Your Ref: 2026/91264

Our Ref: B/01346

18th June 2026

Land off Lindley Moor Road, Lindley, Huddersfield, HD3 3SX - (KIRK) - Discharge of details reserved by condition 15 (drainage strategy) and 17 (oil interceptor) on previous permission 2022/91477 for Hybrid Planning Application for the erection of an industrial unit for B2 /B8 use, with ancillary office space and associated access, parking, groundworks and landscaping in conjunction with an outline application for mixed use development use class E(b),B2 and B8, with ancillary office space and associated works

Project - Originator - Zone - Level - Type - Role - Number
800150-HEX-XX-XX-DR-C-9200

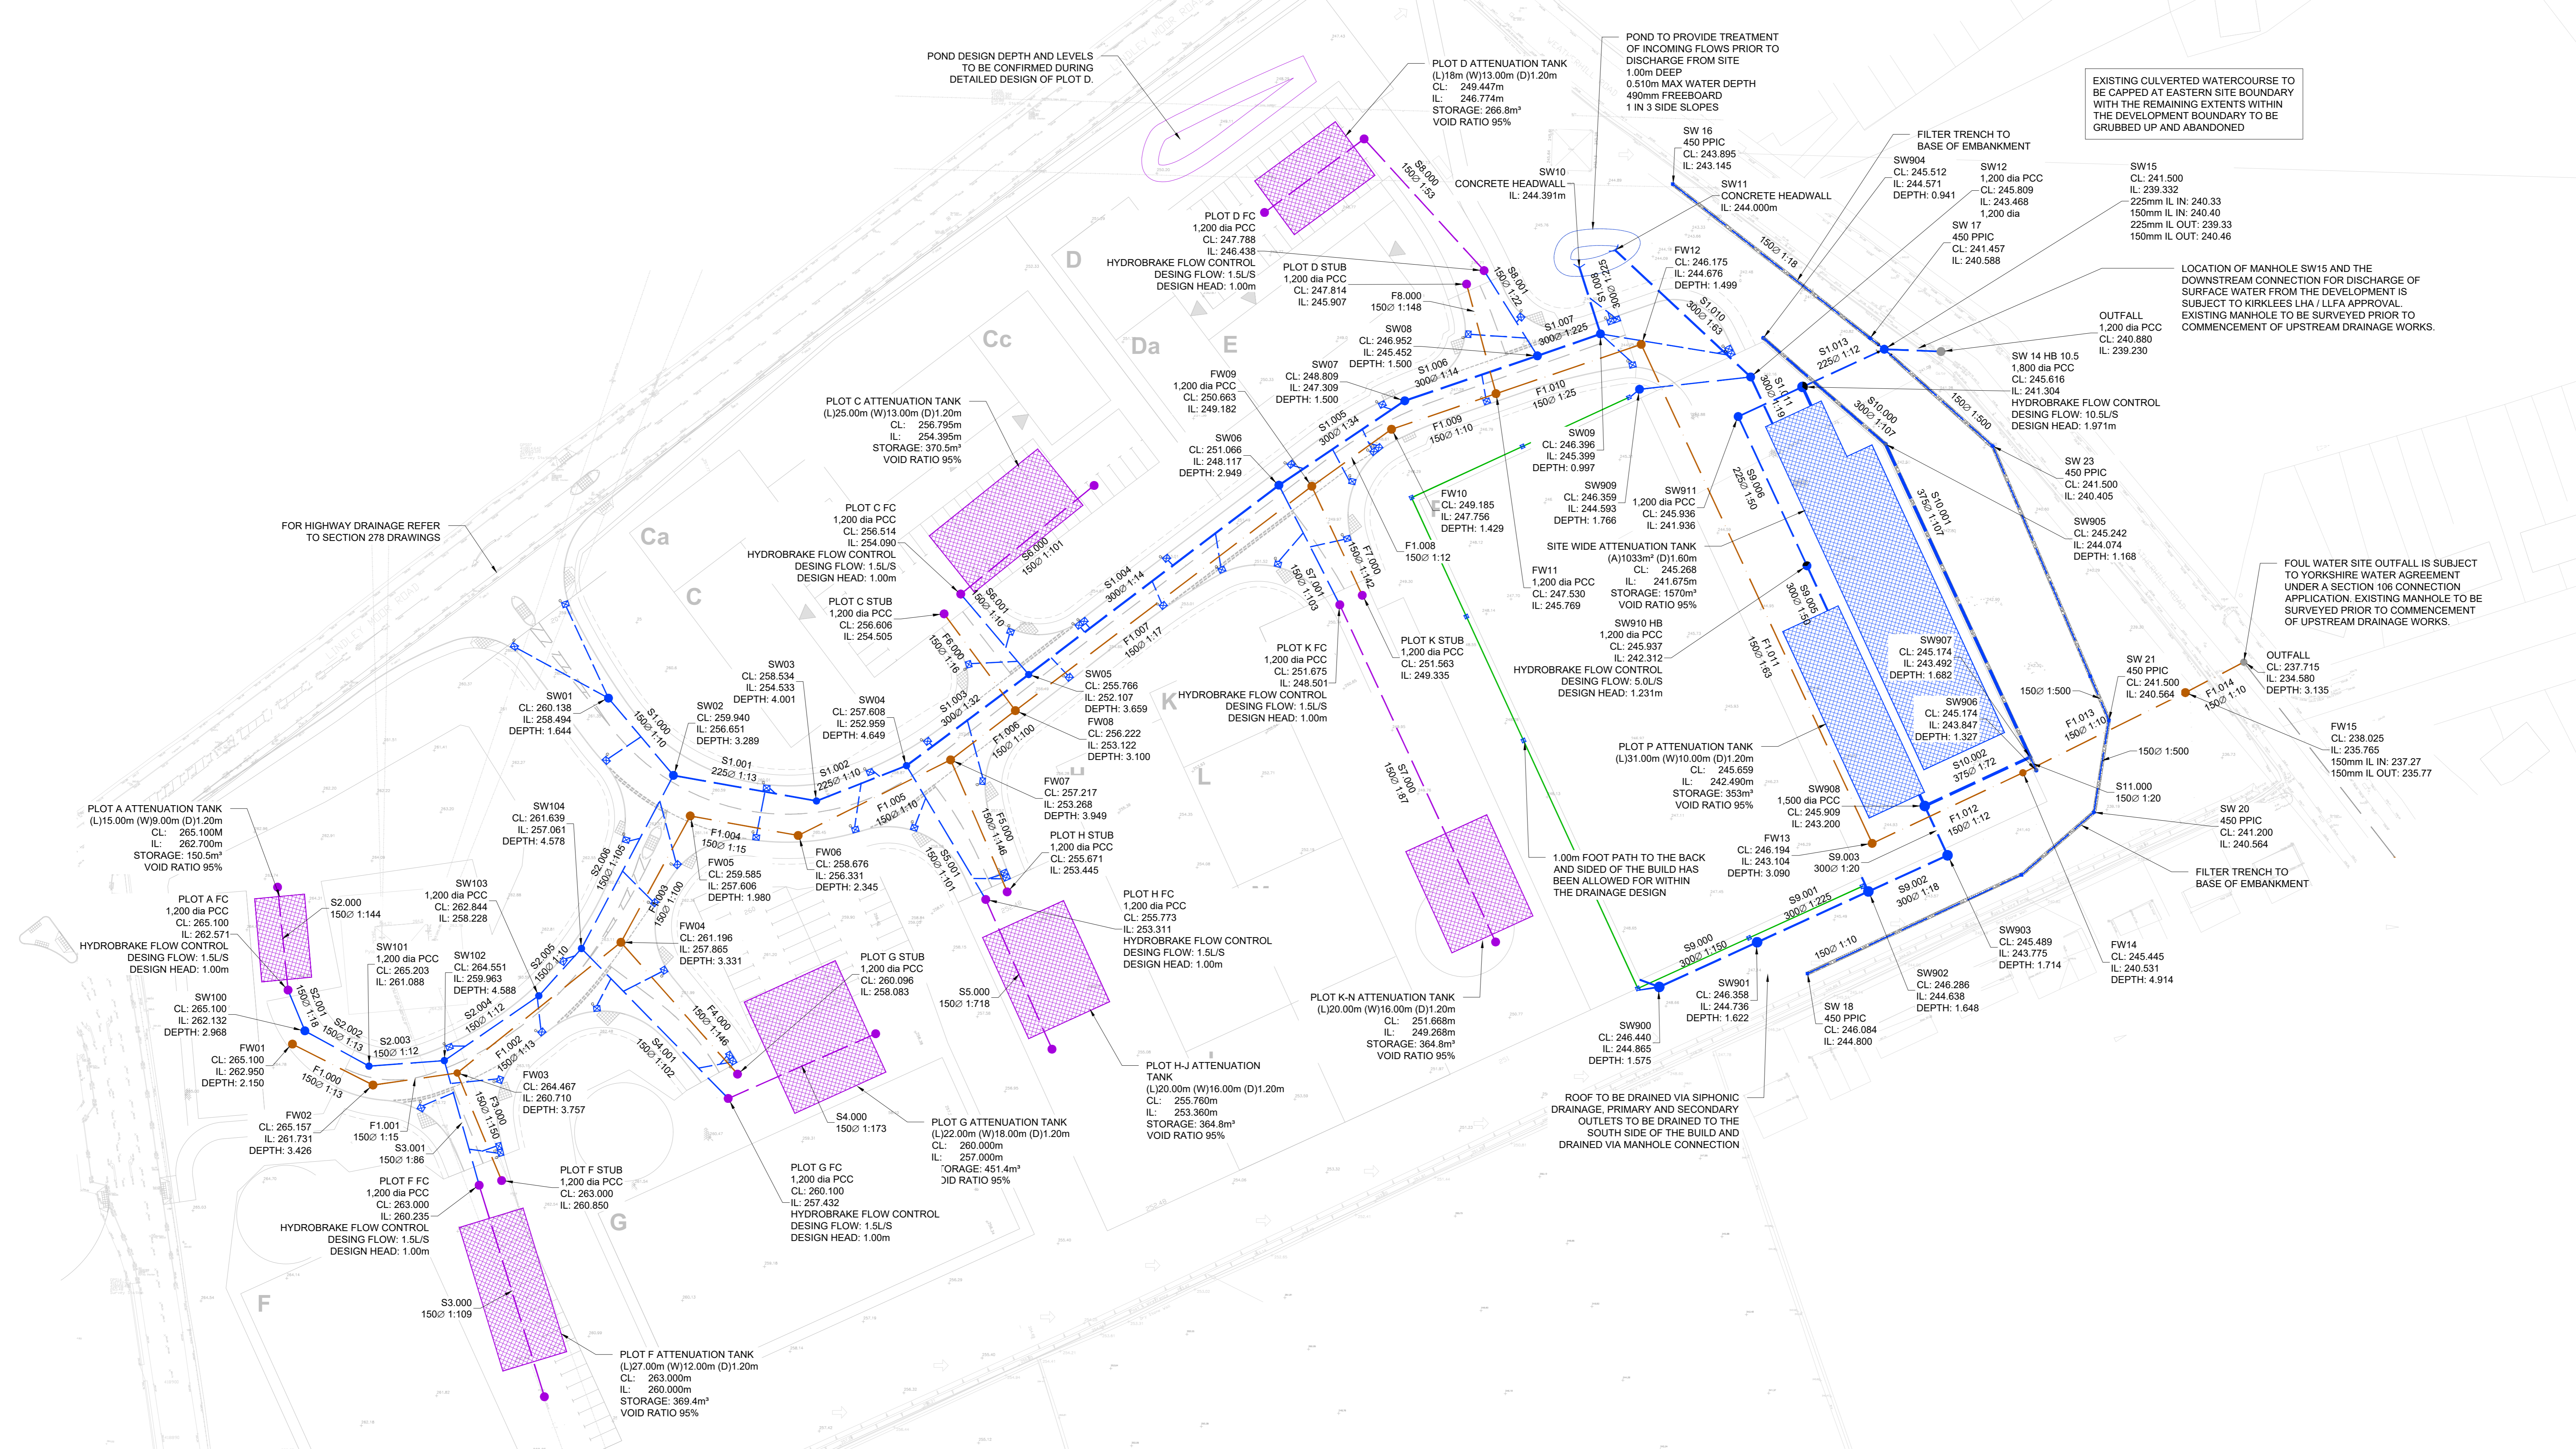
Yorkshire Water have no objection to the discharge of conditions 15 and 17.

Yorkshire Water has no objection in principle to:

- 1) The proposed separate systems of drainage on site and off site
- 2) The proposed point of discharge of foul water to the public 225mm diameter combined sewer in Weatherhill Road
- 3) The proposed use of a pond and filter drains for the treatment of surface water
- 4) The submitted drawings shows surface water proposed to be drained to watercourse at a rate limited to 10.5 litres/second

submitted on drawings 800150-HEX-XX-XX-DR-C-9200 (revision P02) and 800150-HEX-XX-XX-DR-C-9201 (revision P01) both dated 08/05/2026 that have been prepared by Hexa.
